Horsham District Council

Principal Areas of Disagreement Summary Statement

Version Number 1
Submission Date: 05-11-2023

Table 1 – Outstanding Principal Areas of Disagreement				
Topic of Concern		Explanation	Remedy Measures	Likelihood of Resolution
Air Quality				
HDC01	Air Quality Mitigation Plan for construction phase of the development (air emissions mitigation strategy)	<p>i) Lack of a stand alone Air Quality Plan for the construction phase of the development.</p> <p>ii) The concern is that air quality improvements in the Cowfold Air Quality Management Area (AQMA) do not stall and that the improvements are continuous and maintained into the future.</p> <p>iii) The Air quality and emissions mitigation guidance for Sussex (2021) draws on Defra’s methodology for the appraisal of impacts produced by a project. It requires that each application (major and/or in relevant proximity of an AQMA) is supported by an air quality mitigation plan detailing measures to mitigate and/or offset the impacts and setting out itemised costing for each proposed measure.</p> <p>https://sussex-air.net/wp-content/uploads/2022/09/Sussex-AQ-Guidance-V.1.1.2-2021.pdf</p>	<p>Applicant to undertake Air Qu

**OAKENDENE SUBSTATION
INDICATIVE LANDSCAPE PLAN**

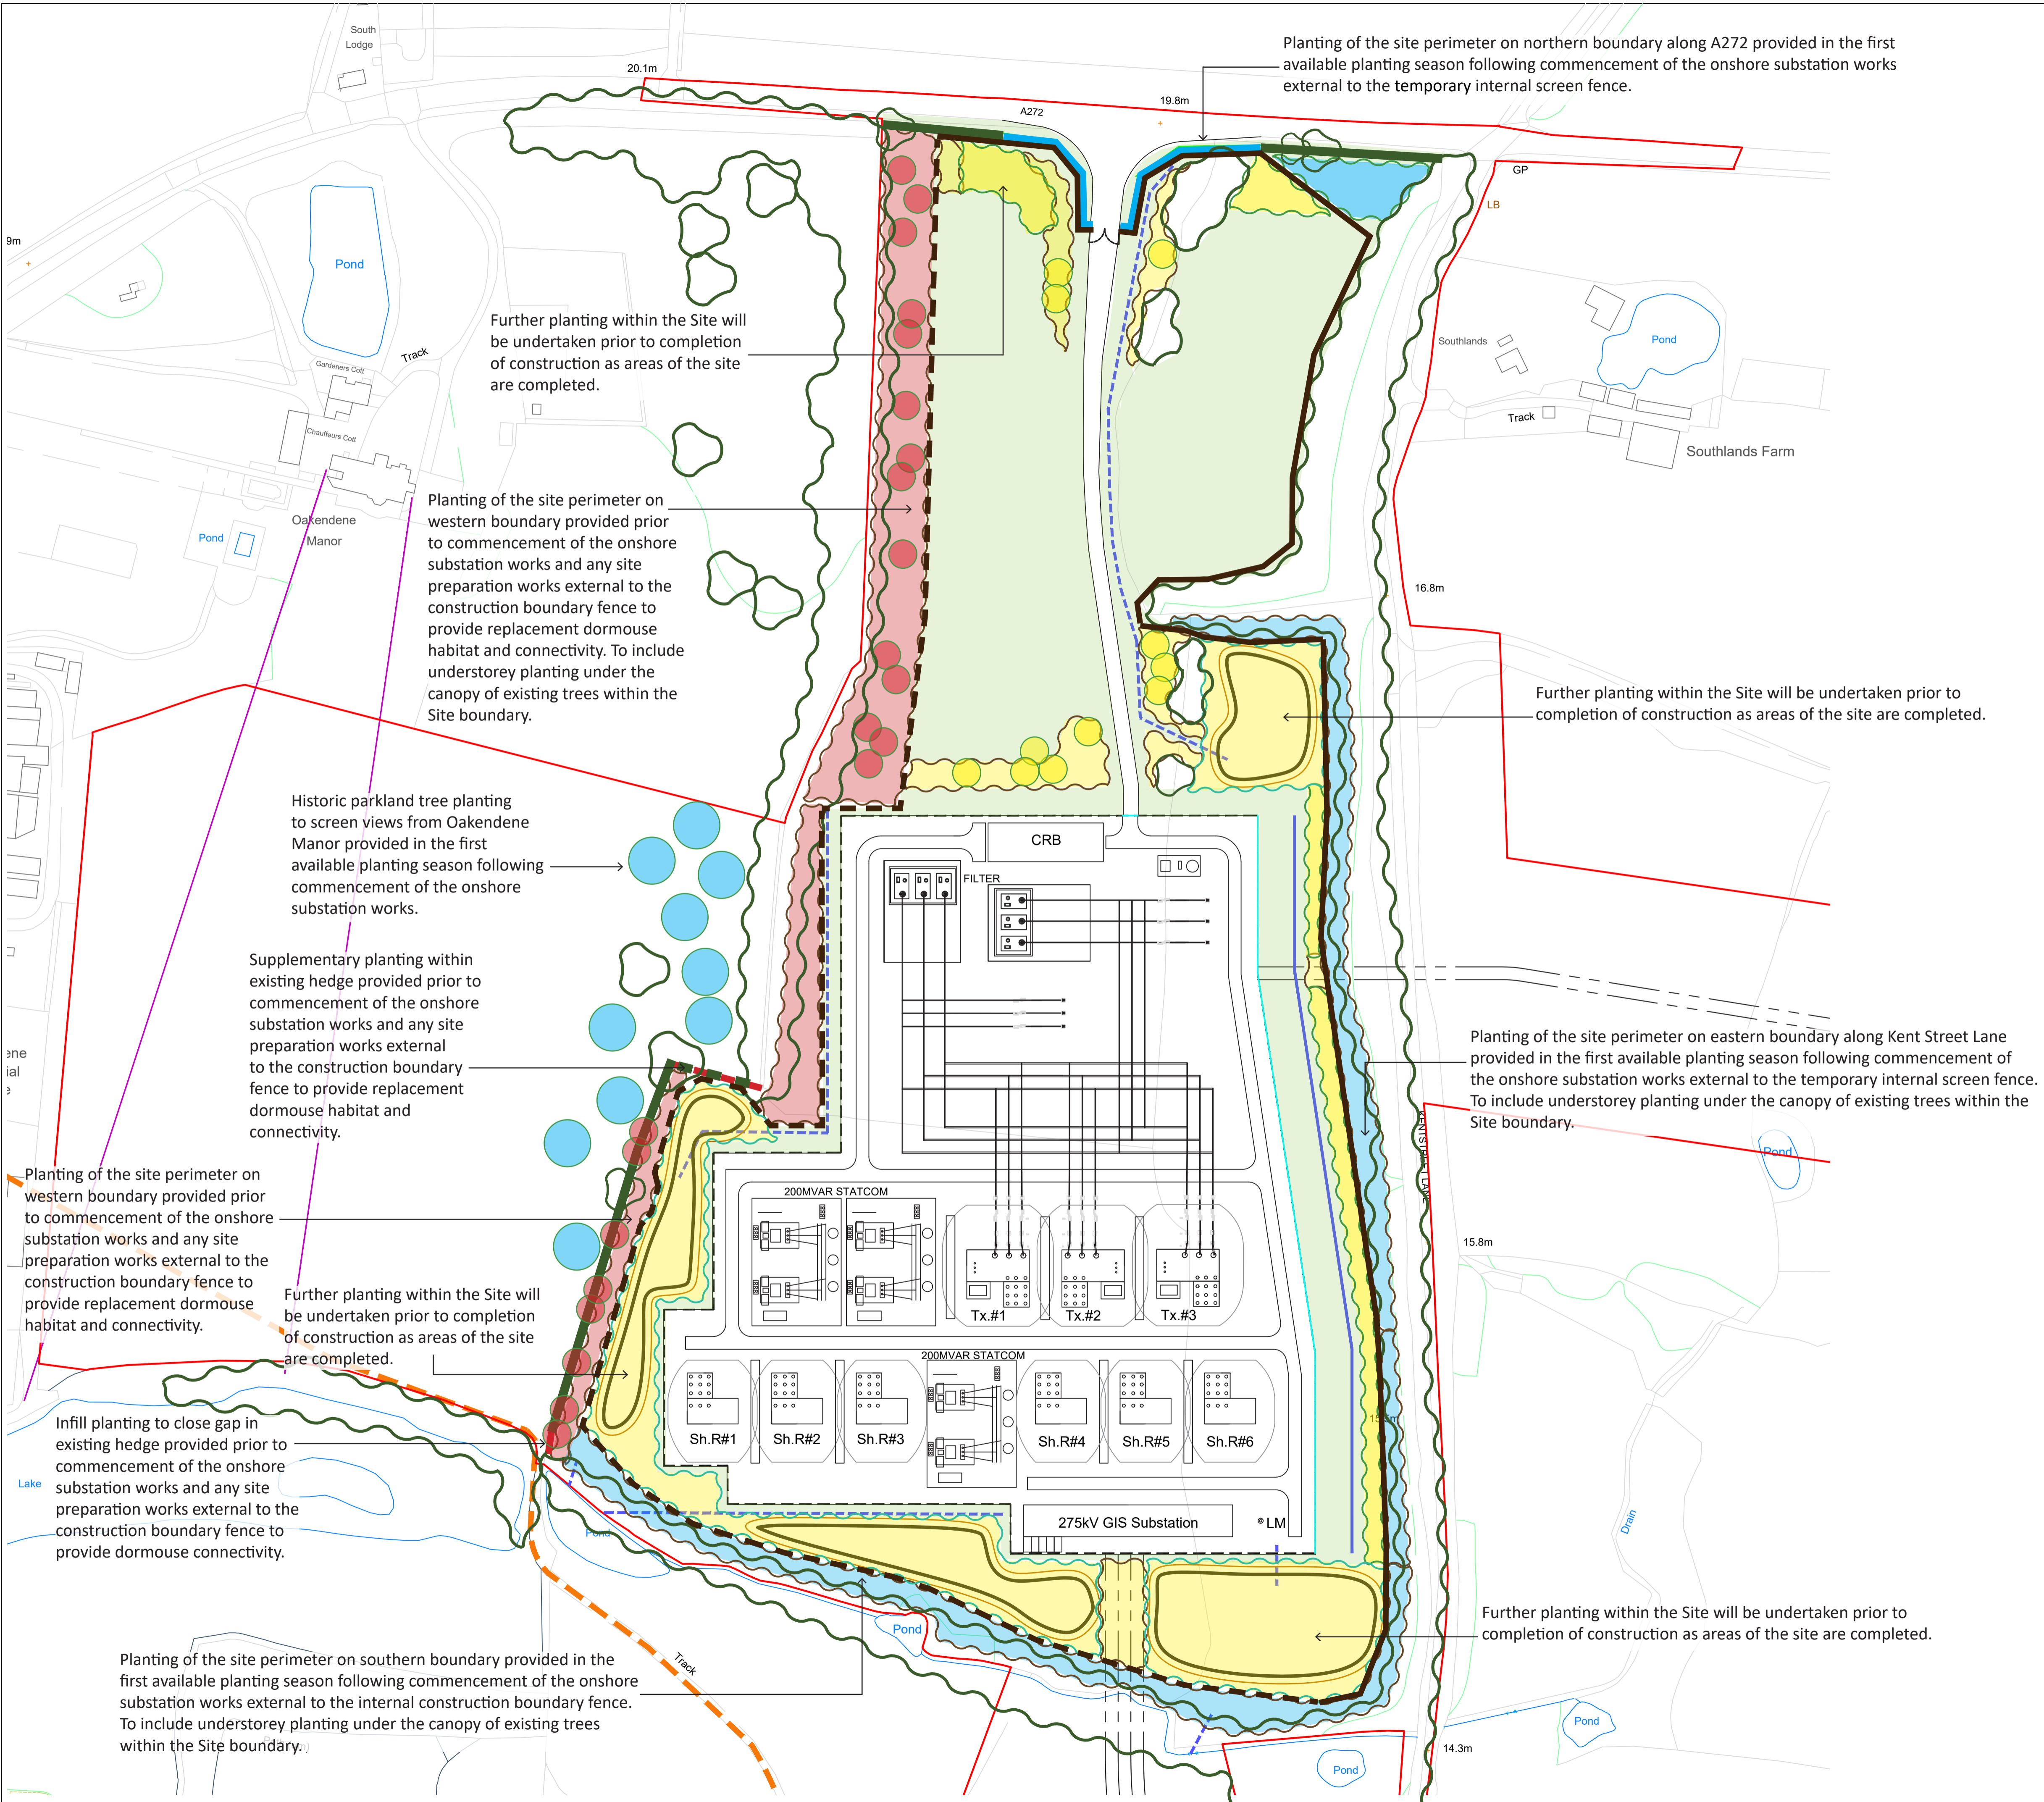
HDC25	Operational phase of Oakendene Substation site	<p>Landscape and visual impact assessment recognises significant impacts at operational stage around the Oakendene substation.</p> <p>Identified effects are assessed as softening and reducing in significance, based on design landscape</p>	<p>Applicant to amend Commitment 68 to take account of WSCC's land management guidelines and local character areas guidelines and characteristics within the J3 Cowfold and Shermanbury Farmlands, of the Horsham District Character assessment.</p>	Likely

principles and parameters proposed for the Oakendene substation presented in the documents, included DAS (including, amongst others, indicative developable area, site layout, building scale and form, heights (including concrete base) and materials palette), and as proposed mitigation measures (planting) matures. The LVIA conclusions are also based on the inclusion of these measures.	Applicant to amend and refine draft DCO 8(1) (a) – (f) for onshore substation for more precise parameters to be fixed, to reflect the indicative site plan and building shown within DAS	
HDC26	Landscape and Visual Impact Assessment	<p>i) LVIA does not include assessment of relevant individual receptors within the core assessment document.</p> <p>ii) The grouping of some of the receptors into a wider bracket is minimising some effects that are considered significant.</p> <p>iii) Equally, overreliance by the assessor on the success of the general concept of replacement planting, is currently playing down the identified adverse effects in the core document which without delving down into the various associated appendices, this will not be picked up and is difficult to follow.</p>	Consistently apply the proposed LVIA methodology so that all receptors are given due consideration and the adverse effects are clear to the reader.	Likely
